DECISION DELEGATED TO DEVELOPMENT MANAGER

Application No: H08-1214-18 **Applicant:** Mr S Dobney

Proposal: Details of site levels and floor levels, external materials, design and position of external boxes, gas flues and soil vent pipes and landscaping. Conditions 4, 5, 6 and 7 of H08-1099-17

Location: Site Adj To 139 Westhorpe Road Gosberton Spalding

| Scale | 1:50, 1:100 | Drawn | AWM | Checked | TAC | Date | 02/11/2017 | Drawing No. | 17/504/PA/002A |

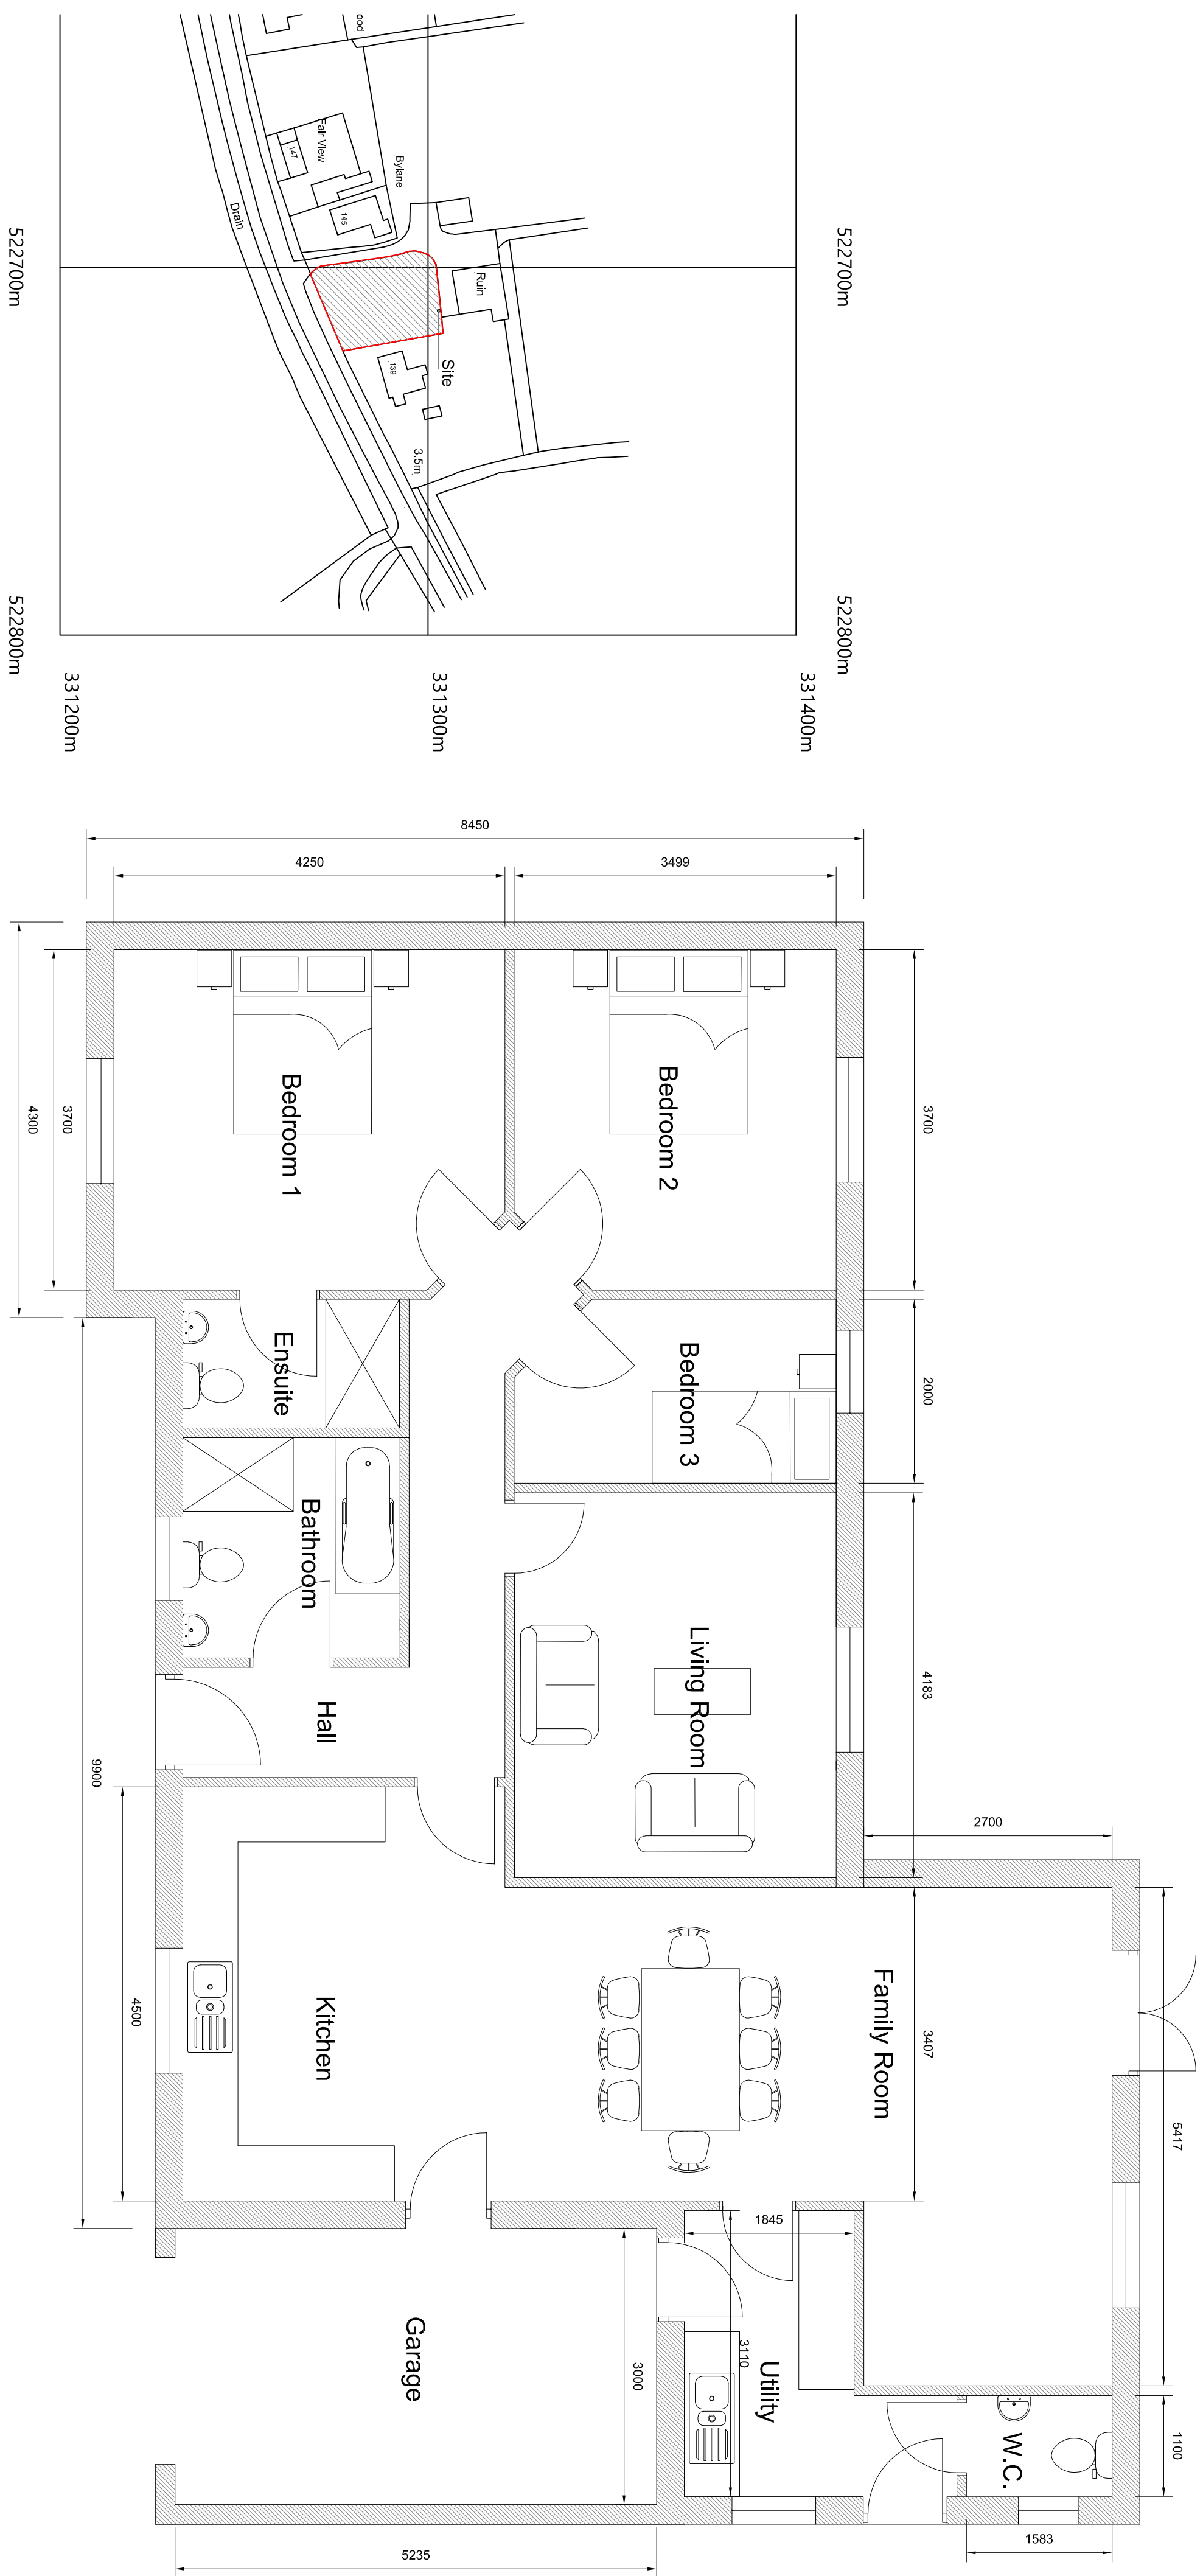
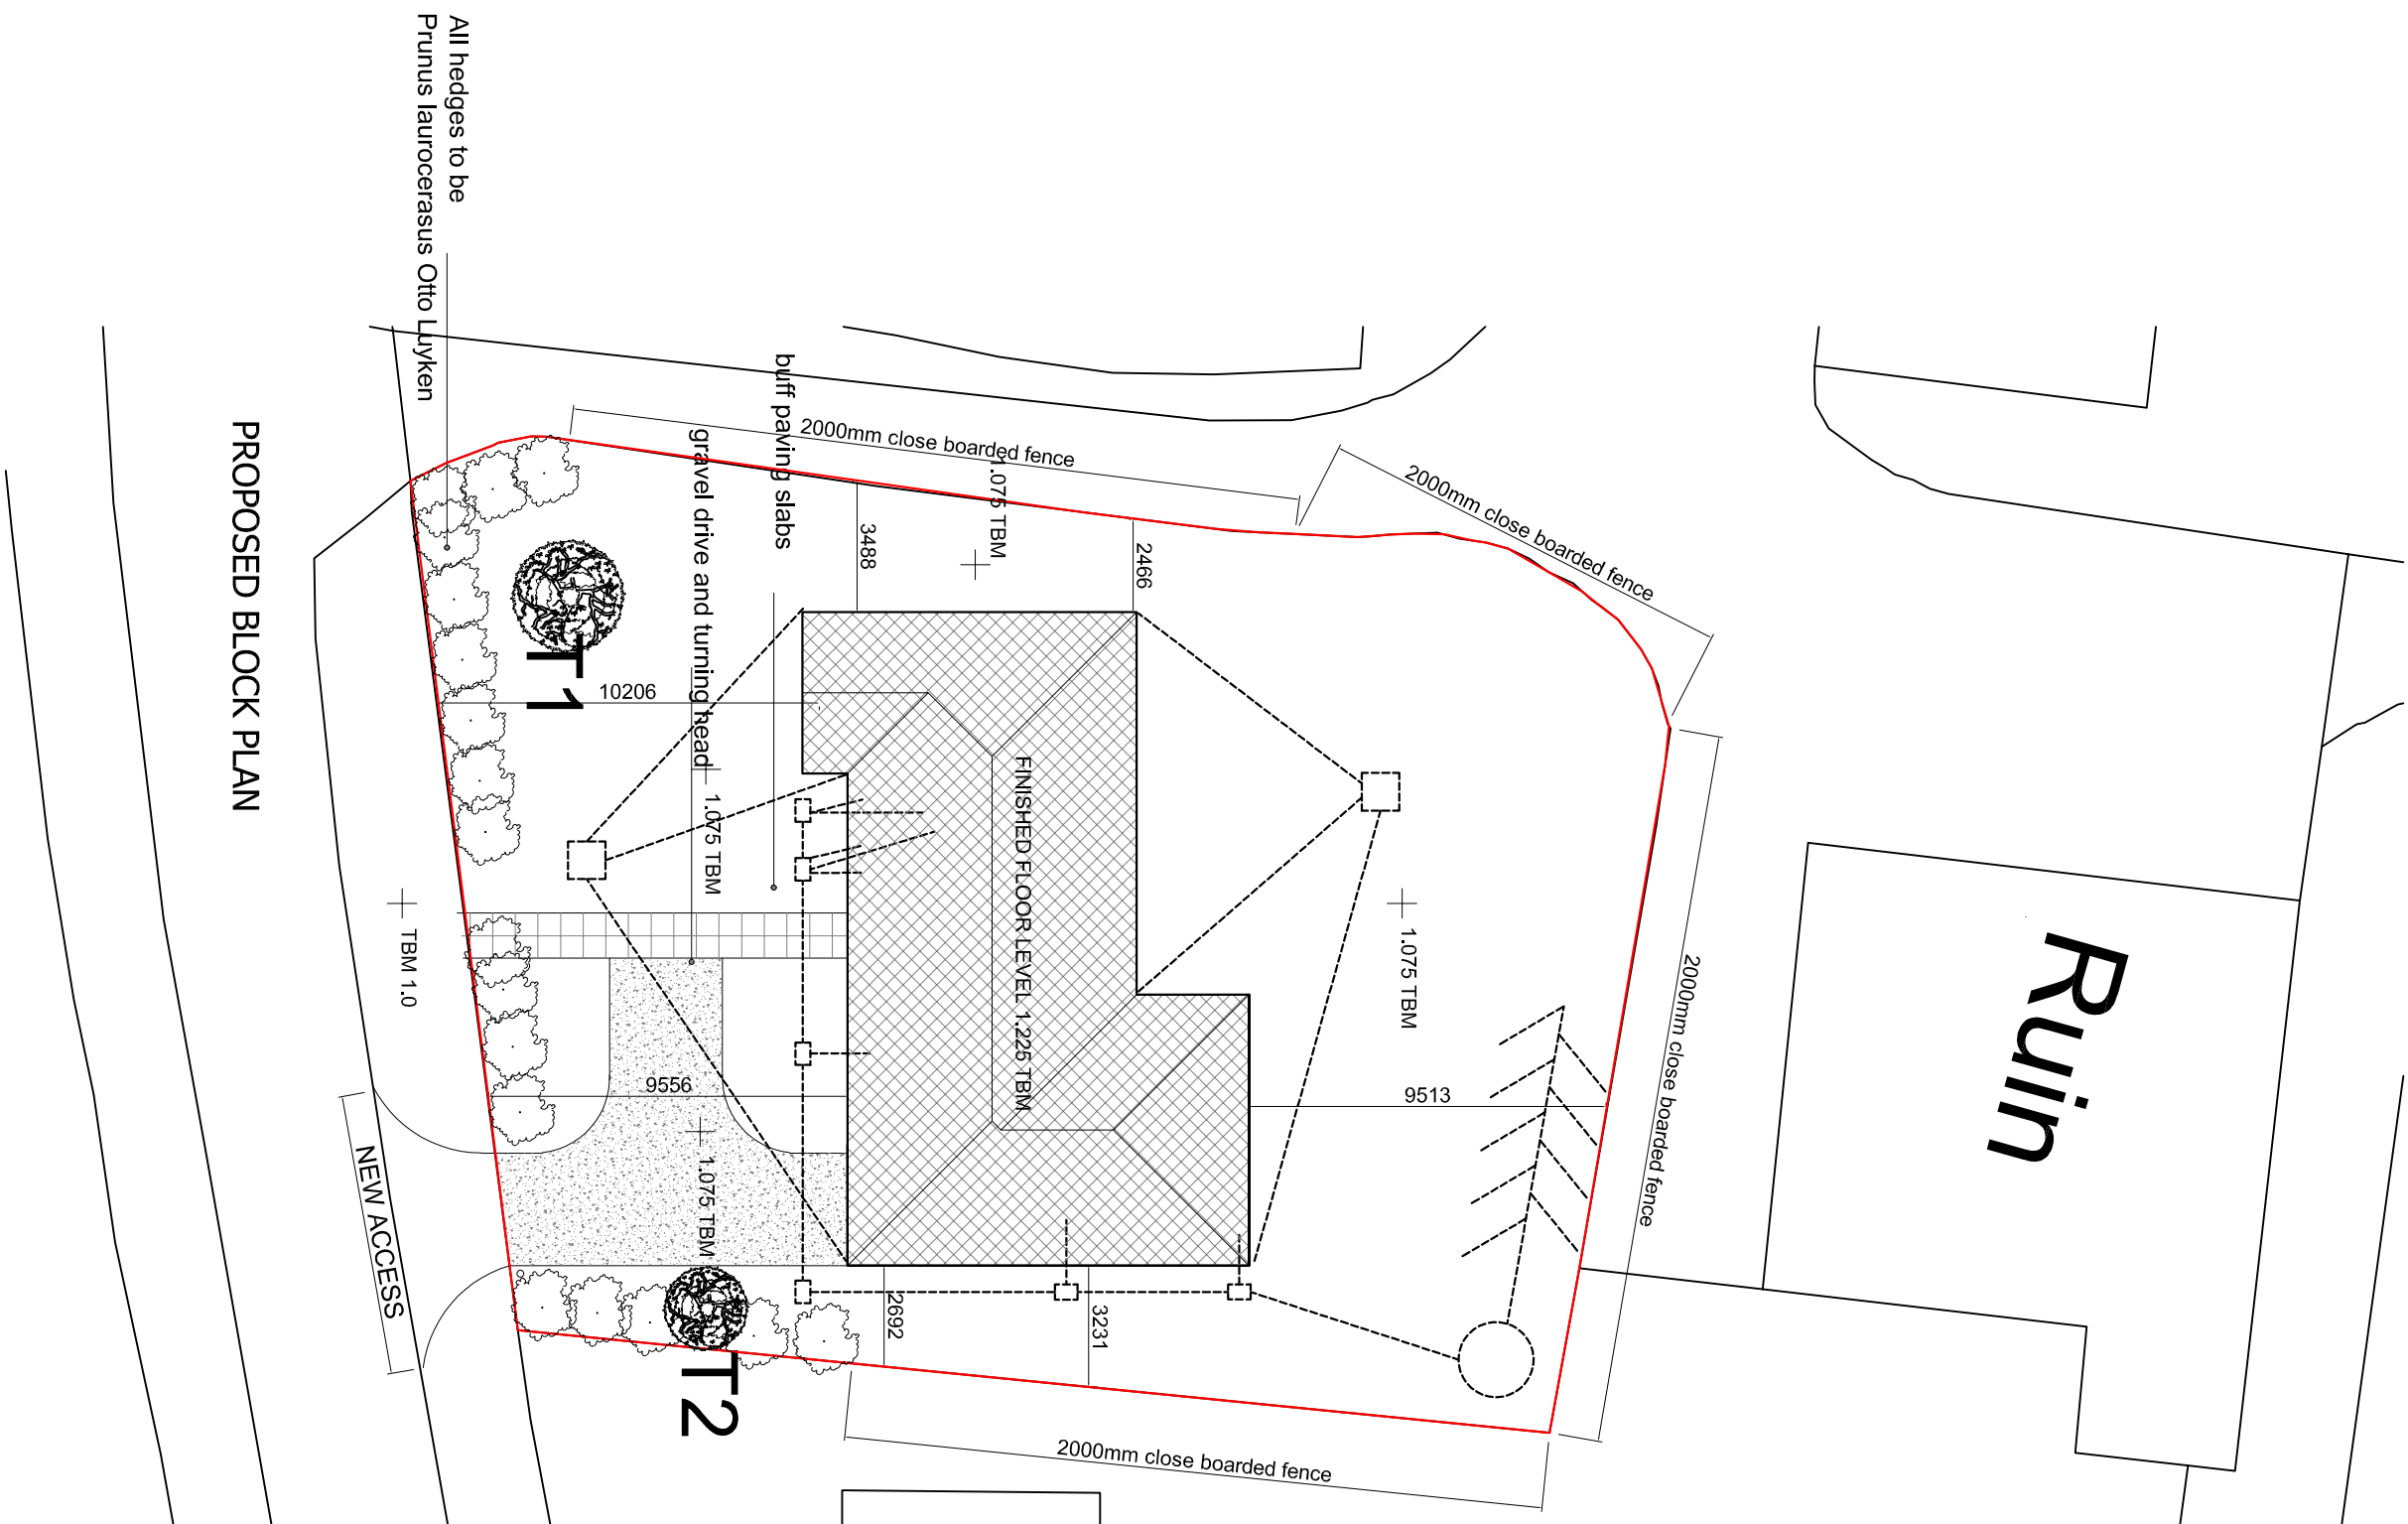
Existing development along this part of Westhorpe Road varies in terms of materials and so the proposed materials (Marley Modern Grey Roof Tiles and Michelmersh Clayton Civic Facing Brick) would not be out of keeping - Red brick is fairly traditional in nature and matches other properties in the vicinity.

Proposed site levels, the design and position of external boxes (side elevation), gas flues and soil vent pipes and scheme of landscaping are all acceptable.
